LU/13/22/PL

Pharos Quay River Road Littlehampton BN17 5BF

Alterations to fenestration and openings. (This application may affect the character and appearance of the Littlehampton (River Road) Conservation Area and a Listed Building).

Martyn White
Principal Conservation Officer,
Planning Services

DRAWING CHANGE DETAILS:		Towns and Sperm and on added to window & door schedule, sash towns removed	
PROJECT:		Pharo's Planning Drawings, BN11 ZSP	
TITLE:		Window Elevations (Sheet 3 of 3)	
PROJECT NO.:		21-75-869W	
S.I.H.		E3	
CHECKED BY:		P.F.	
SALES PERSON:		Kean O'Neil

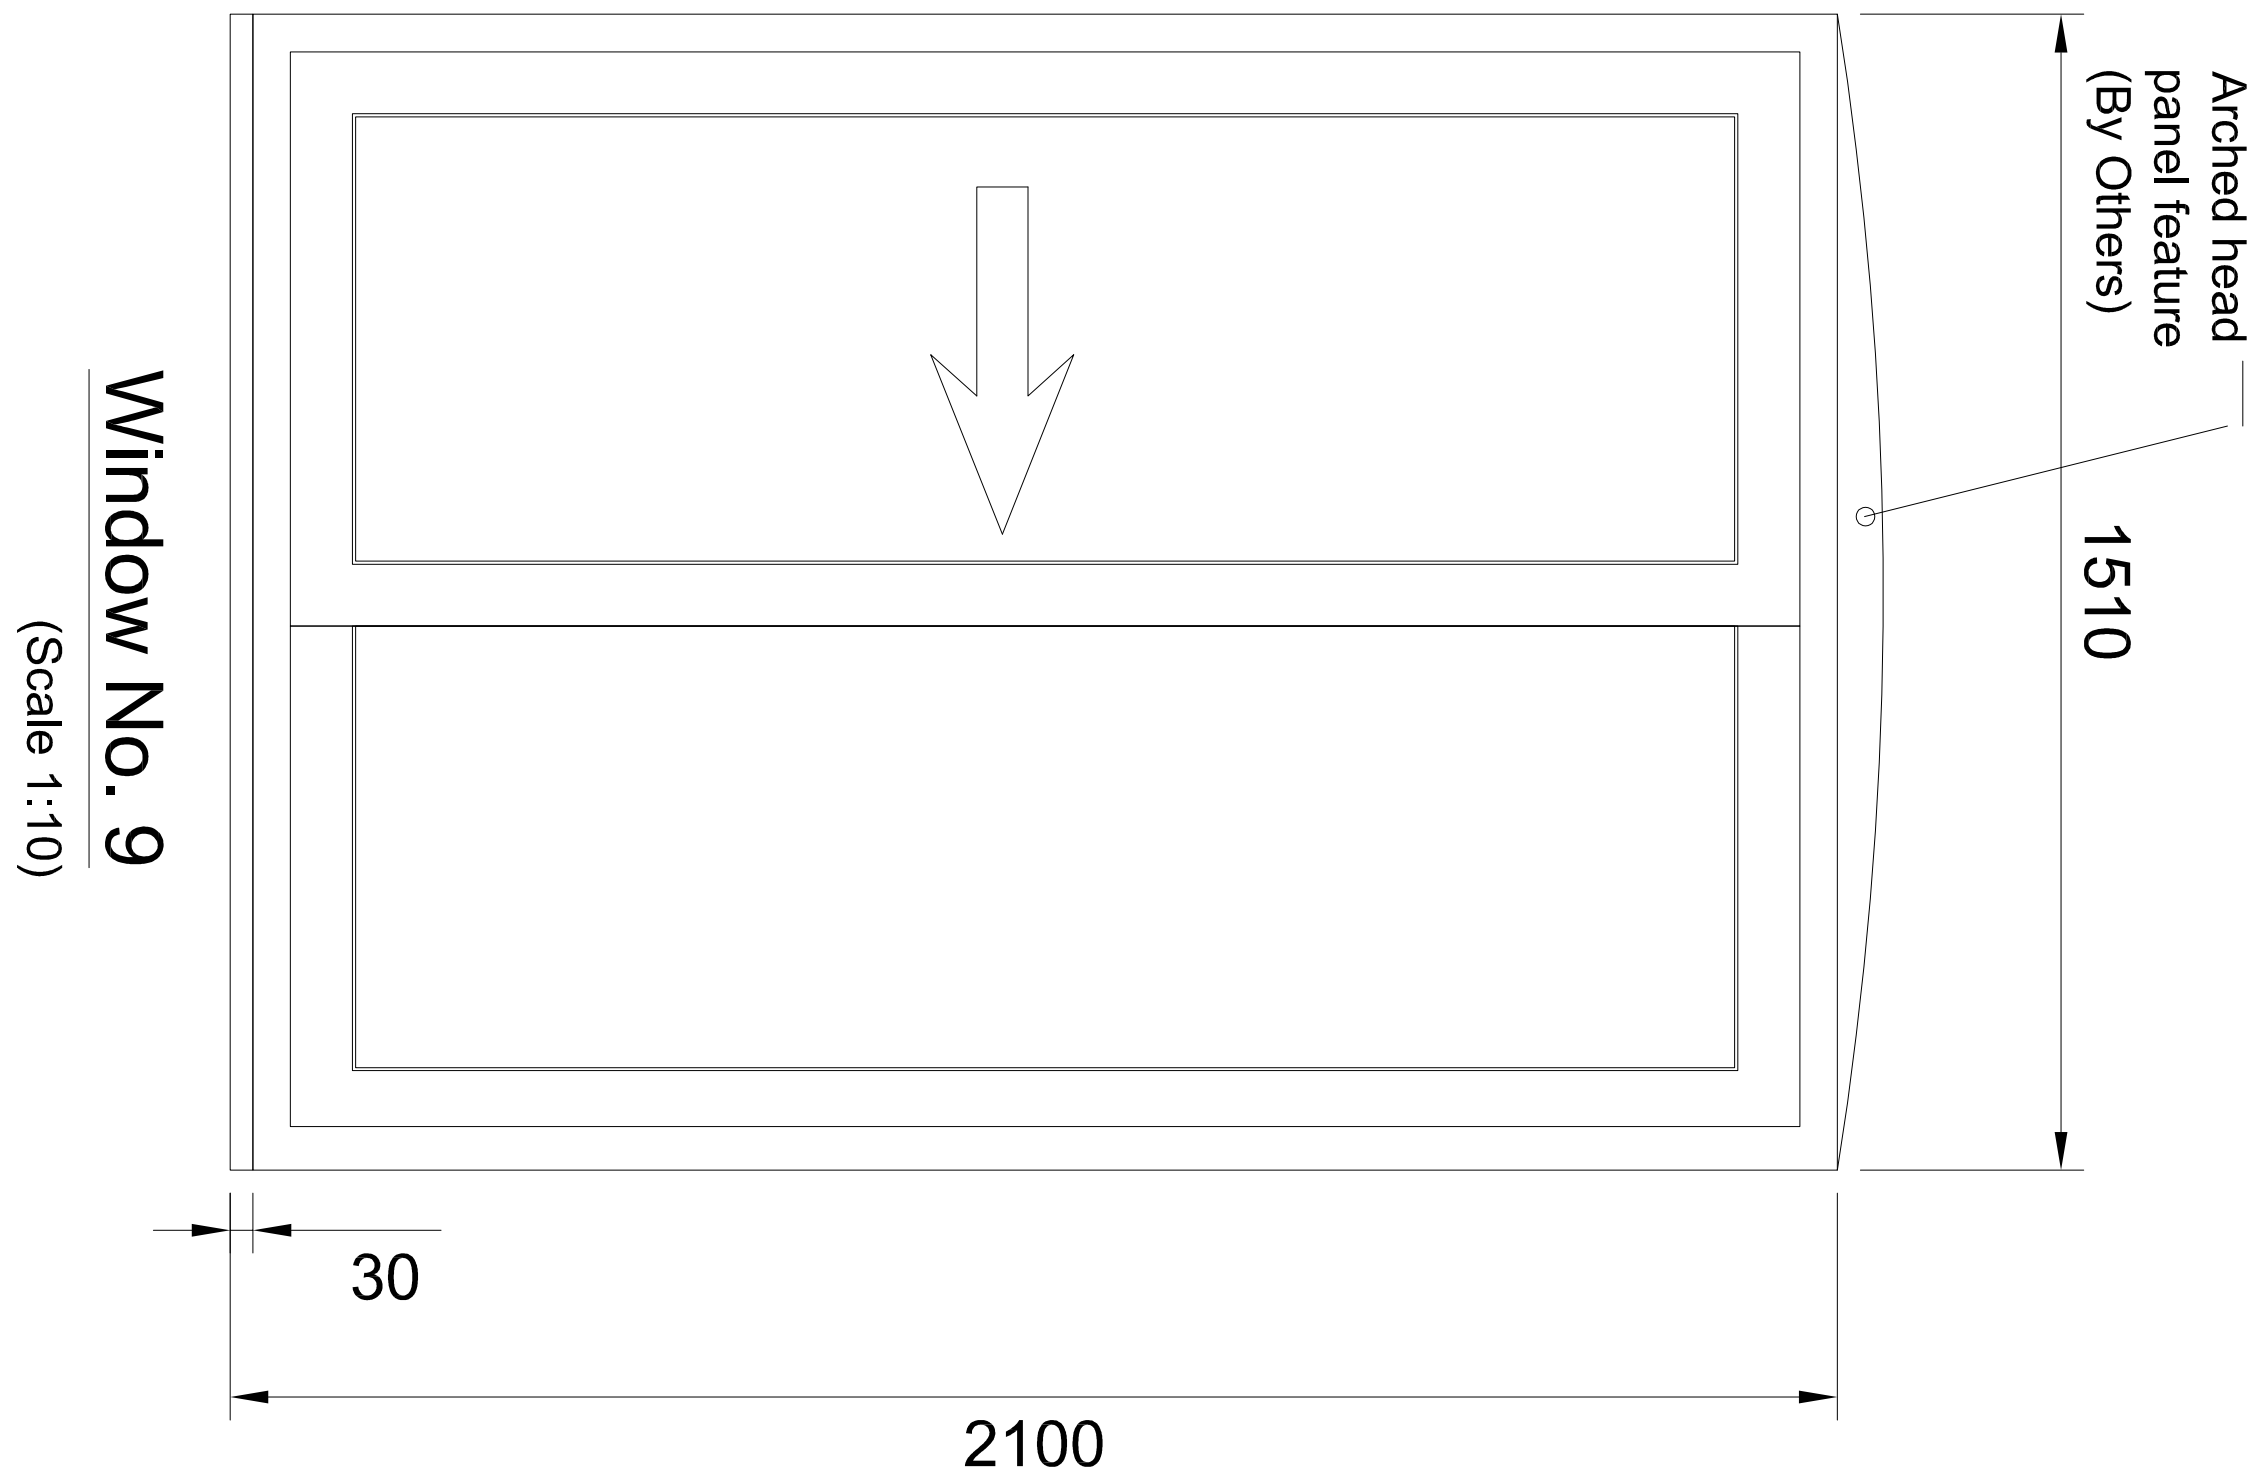
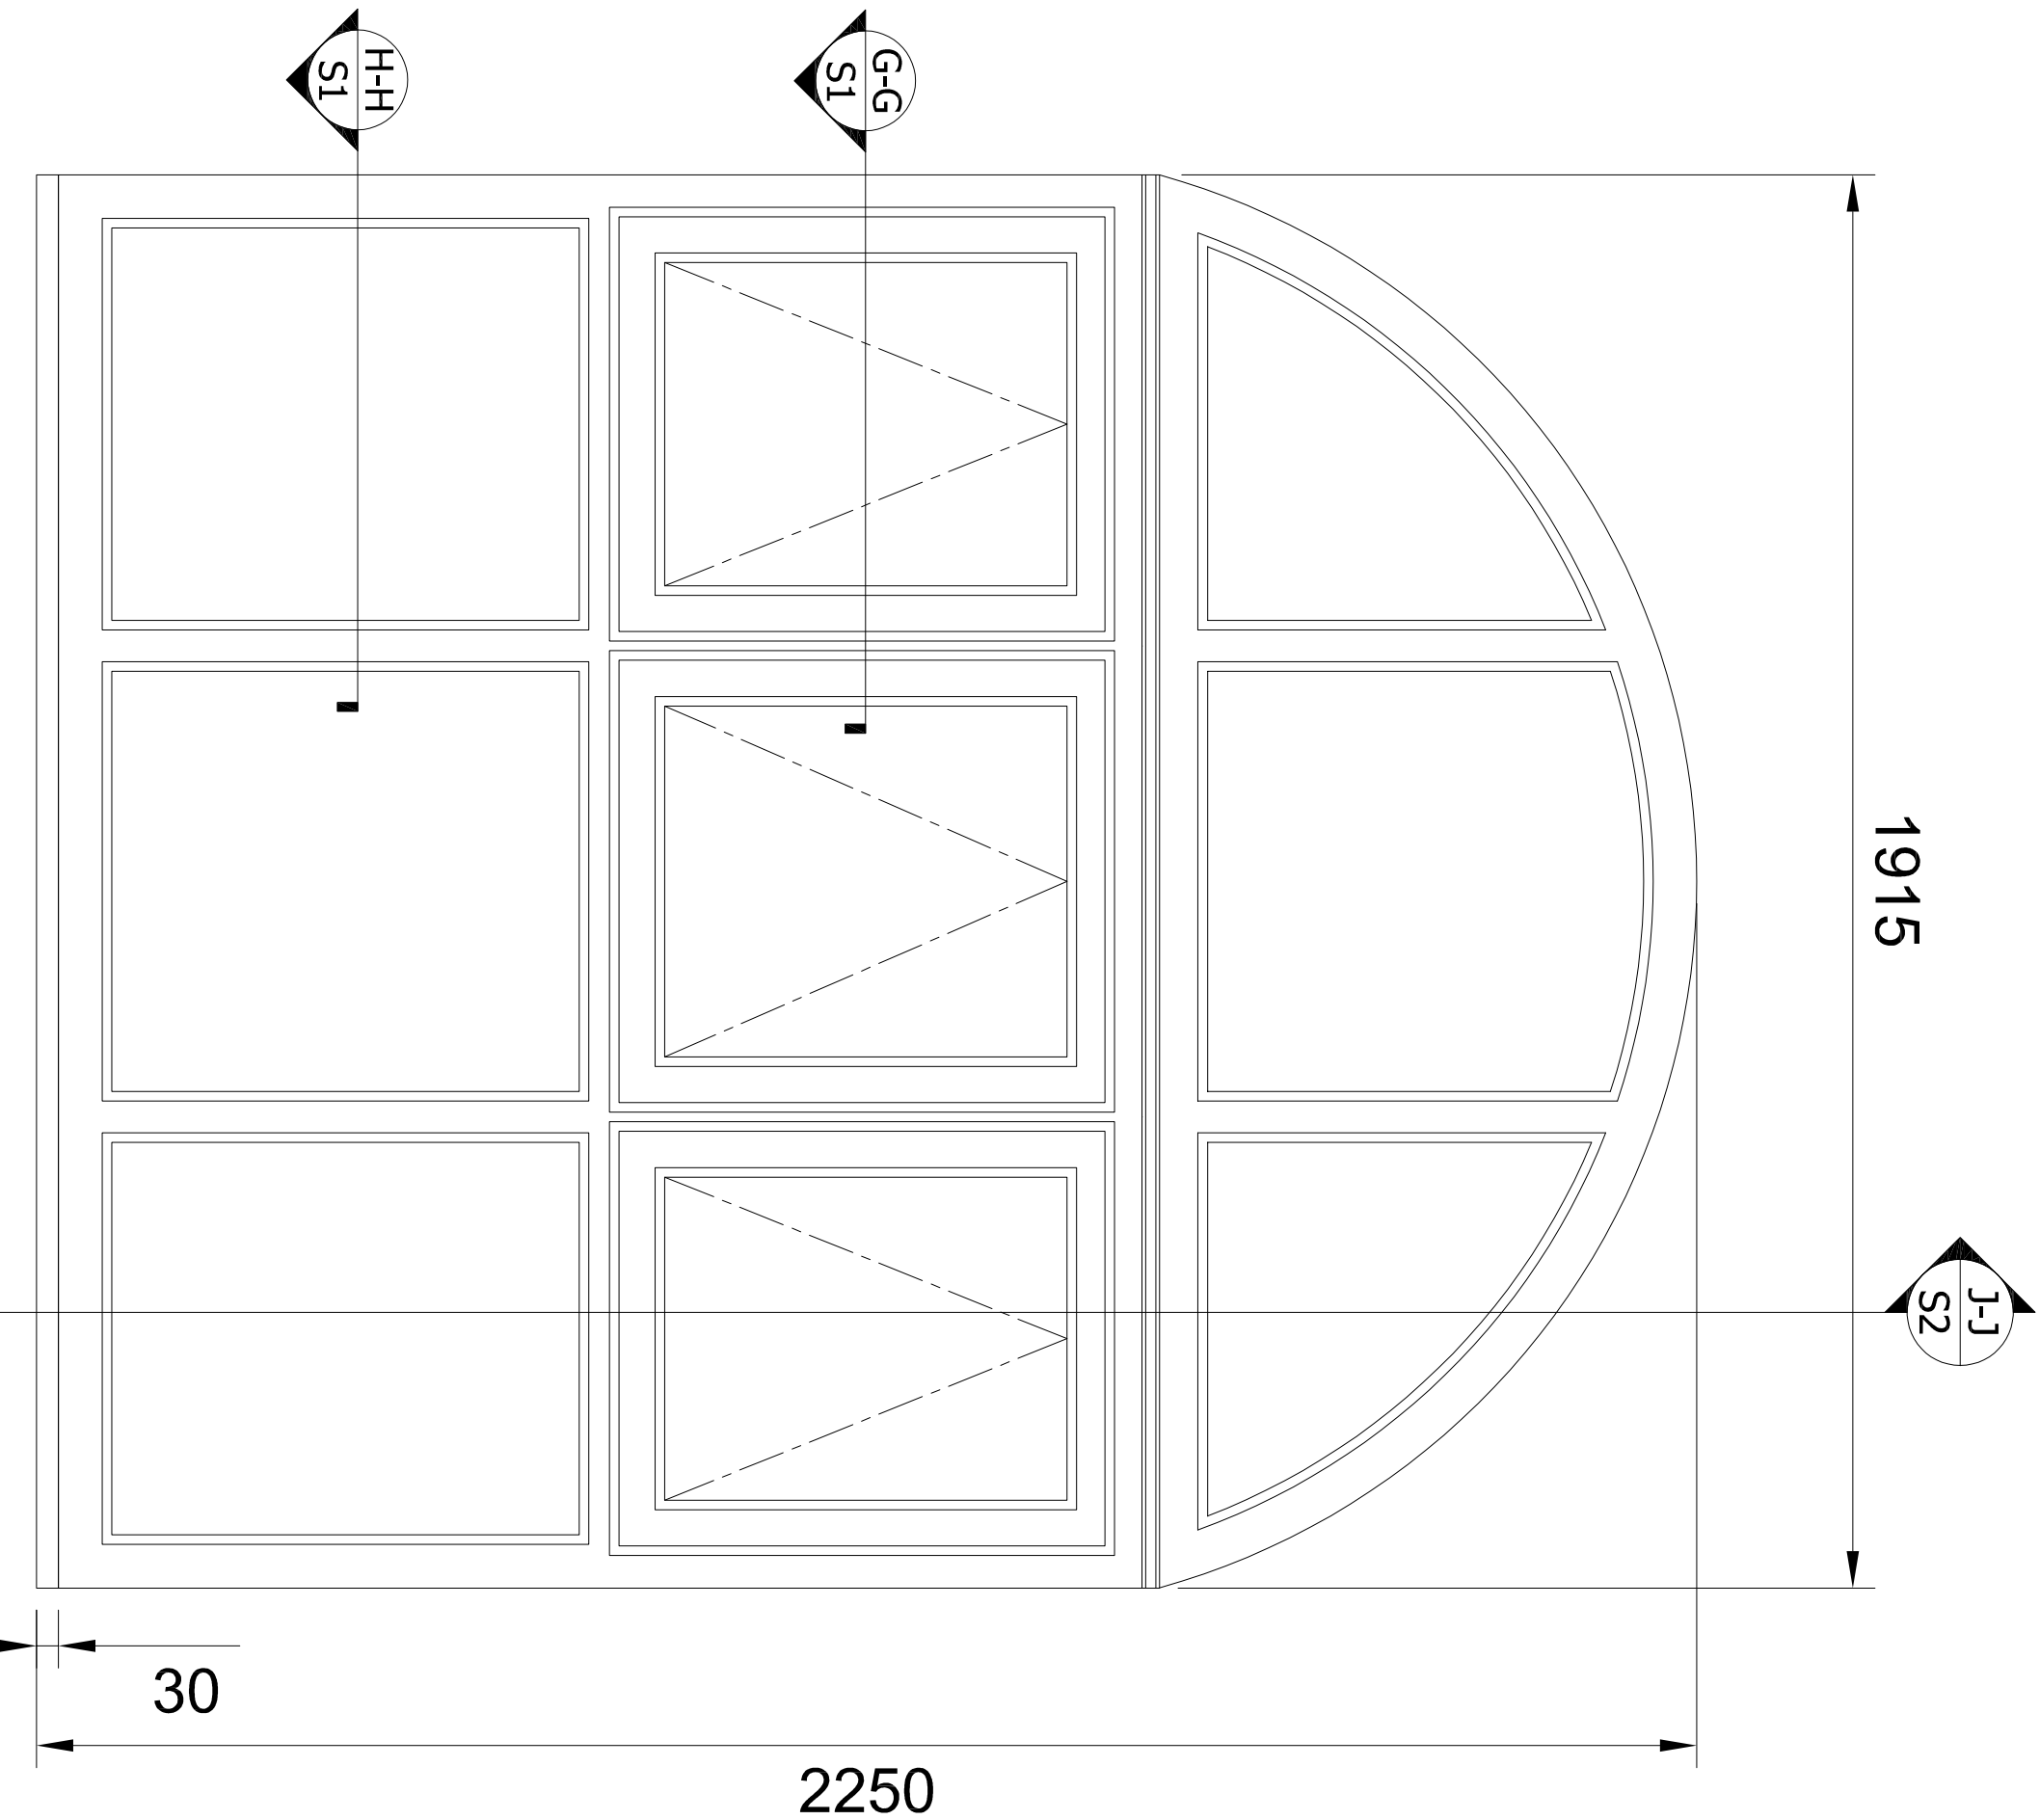
Windows are an important feature within a building, and their replacement should be carefully considered. It is suggested by the applicant that the replacement windows are of a similar appearance to the existing ones. The heritage statement identifies that the replacement doors, whether main entrance doors or sliding patio doors, will be renewed on a like-for-like basis with a wood grain effect PVCu composite doors. Likewise, it is identified that the plastic soffits and fascias will enclose the eaves.

It is considered that this proposal is problematic; UPVC windows are not a traditional or vernacular material and are unsuitable for use in historic buildings or in particularly sensitive areas such as conservation areas. Although designs have improved, faithful replication remains deficient in many areas. They are often less refined, and the size of the frame is of necessity usually larger than that of a traditional timber window giving an obtrusive and chunky appearance. Applied glazing bars are employed which are often too thick or sandwiched between the two layers of glass, and not detailed enough for historic buildings. Further, the visual effect of shiny modern plastic is out of keeping with more traditional materials.

Whilst it is unfortunate that the original windows were not vertically sliding sashes, it is suggested that this application offers the opportunity for them to be replaced with something more in keeping with the conservation area. This could either be vertically sliding painted timber sash windows or potentially an alternative material such as white powder coated aluminium sash windows which could provide more slender proportions, and which would have a far more appropriate opening mechanism than top hung sashes. This far more appropriate operating mechanism would go towards ameliorating, to some extent, the adverse impact of UPVC.
